Our Ref: MWMW/LUK11-18423_02_Bulls Bridge Post Submission Consultee Responses

Re: Proposed Aggregate Recycling Plant, Asphalt Production Plant and Gully Waste Recycling Plant, Bulls Bridge, Hayes

We are writing on behalf of our Client, FM Conway Ltd. in respect of the Full Planning Application ('Application') submitted to London Borough of Hillingdon ('LBH') in September 2012 (Planning Reference 13226/APP/2012/2185) for the proposed redevelopment of the former Powergen Site at Bulls Bridge, Hayes (the 'Proposed Development').

Figure 5.2: Proposed Development Elevations

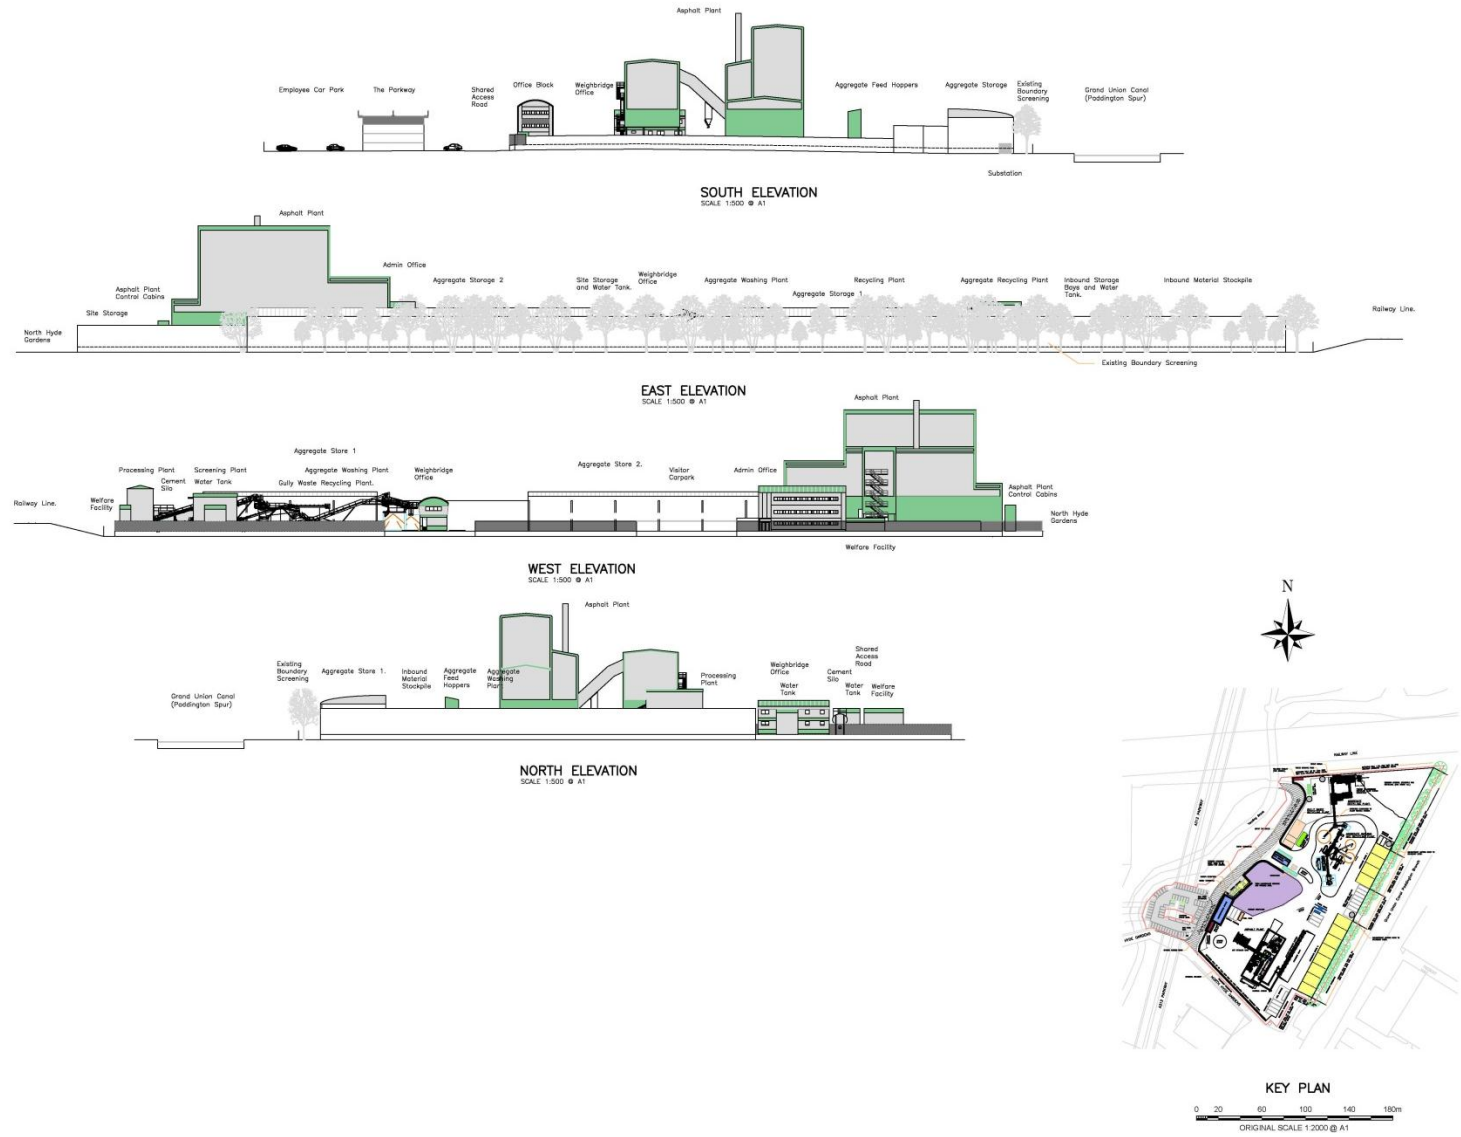
Table 1: TVIA Consultee Comments and Statements of Clarification		
Consultee	Consultee Comment	Applicant Responses
GLA	No requests for clarification or additional information	No responses required.
LBH	<i>"The sectional elevations shown on figure 5.2 indicate that the retained trees on the east boundary will only partly screen views of the acoustic/ storage walls at their current height. The screening effect will be reduced markedly for six months of the year when the deciduous trees are dormant and not in leaf. In addition to this matter, further thought needs to be given to the</i>	Landscaping on the eastern boundary will be augmented as illustrated in the Proposed Development's landscape proposals to ensure that screening of the boundary wall in summer time is maximised. Screening will be reduced during winter months as acknowledged in the commentary that accompanies the AVRs.

Consultee	Consultee Comment	Applicant Responses
	<i>colour and finish of the very high wall adjacent to the canal, which will be partially screened by the existing trees along the tow path. A dark colour and good quality finish should be sought, as it will be some time before the additional planting proposed along this boundary will partially clad and hence soften the visual impact of this structure."</i>	Nevertheless, the prevailing tree structure will continue to break the mass of the wall in winter months so that filtered views of the wall would be afforded. At no time would a bare, solid wall be visible. The wall would be seen as a background feature to the trees. LBH will be consulted in the detailed specification and appearance of the boundary wall and the Applicant will take into account the recommendations made in respect of the colour and finish of the wall.
LBH	<i>"Each of the four elevations demonstrate that the asphalt plant buildings will dominate the site and tower above both the existing trees (on the eastern edge of the site) and the elevated section of the Parkway, to the west."</i>	The appearance of the Proposed Development is dictated by plant requirements. The Applicant has nevertheless sought to reduce the bulk and massing of the asphalt plant, where possible, and has located the structure as far away from the eastern boundary, as is practically and logistically possible.

Figure 5.4: Artist's Impression and Bird's Eye View of Proposed Development

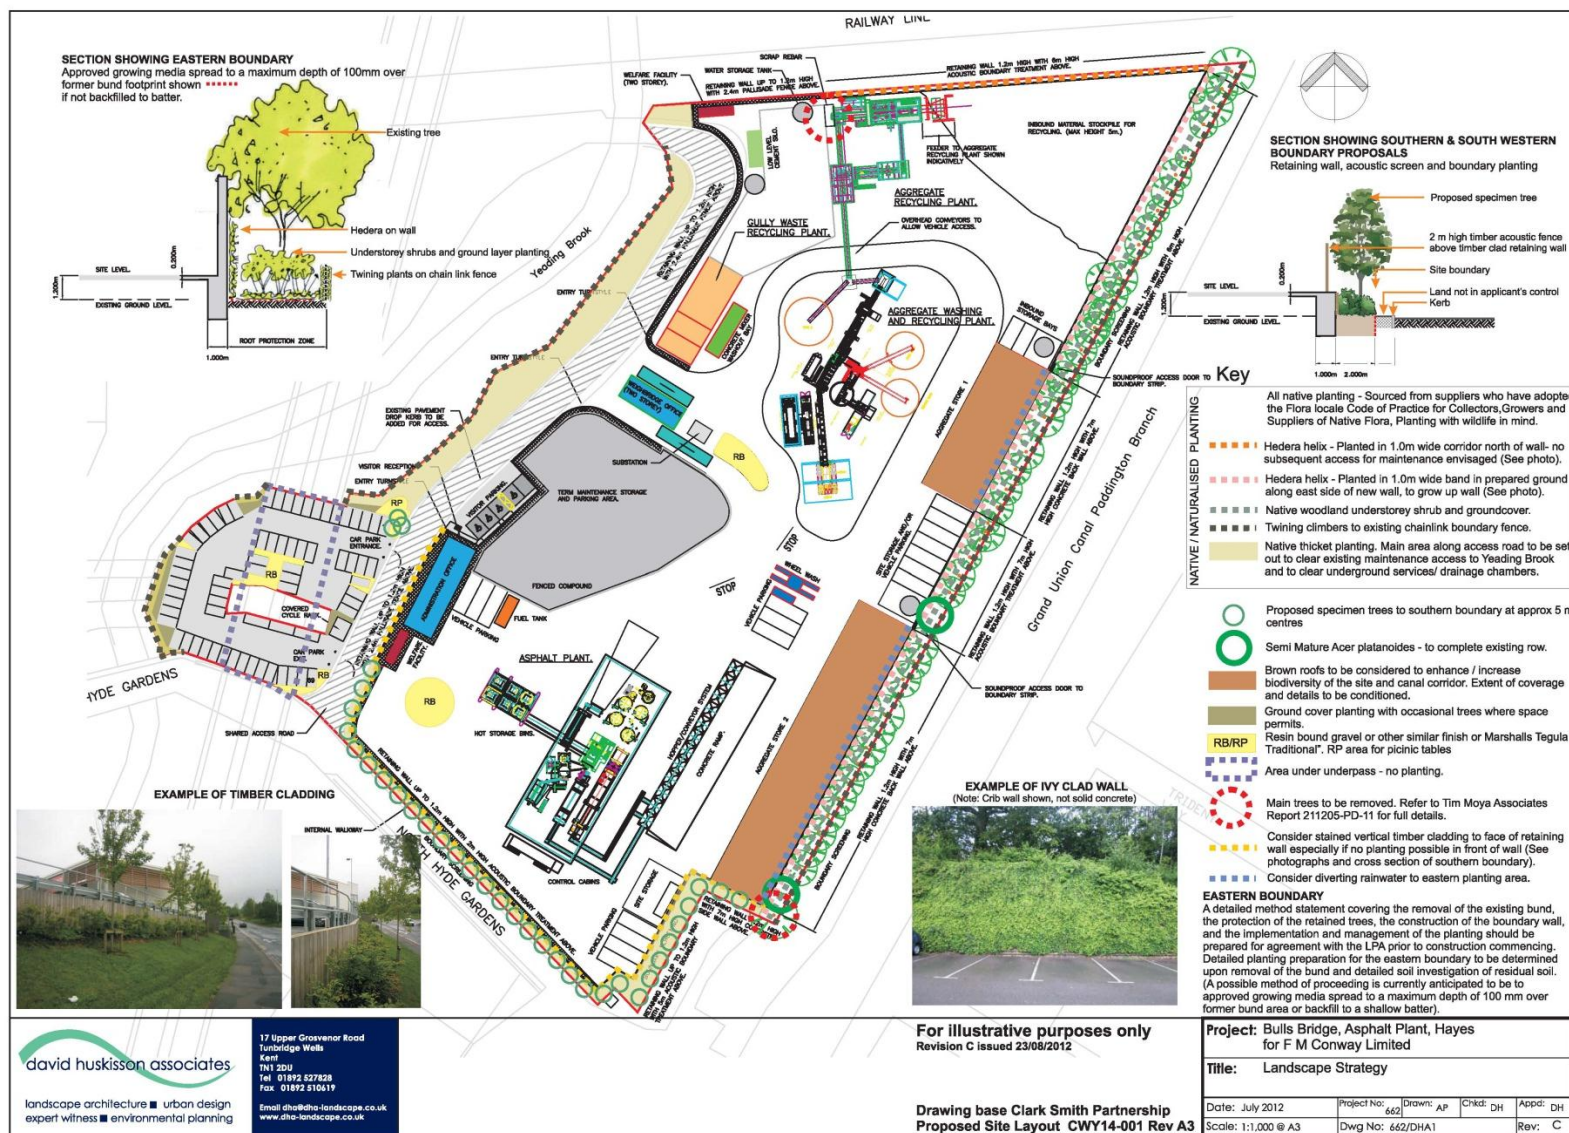
LBH	<i>"Figure 5.4 provides an artist's impression /bird's eye view of the proposed development. It should be noted that this is not a verified view and the height and mass of both of the plant buildings and the office appear to be significantly under-stated. According to the sections all three of these buildings will be higher than the elevated section of the Parkway – with, for example, the plant building enclosures, at 27.8 metres)"</i>	The assessment acknowledges that this figure is for illustrative purposes only. The Applicant's in-house graphic specialist prepared this figure to scale.
LBH	<i>"Similarly, the viewpoints (8.1 – 8.18) considered in the TVIA are all based upon photographs taken during the summer months – when screening by existing vegetation <u>in leaf</u> will be at its most effective. The screening capacity of the existing vegetation will be reduced during winter months when the trees are not in leaf".</i>	As stated above, commentary on the winter conditions within each assessment view was provided within the assessment to ensure transparency and rigour.
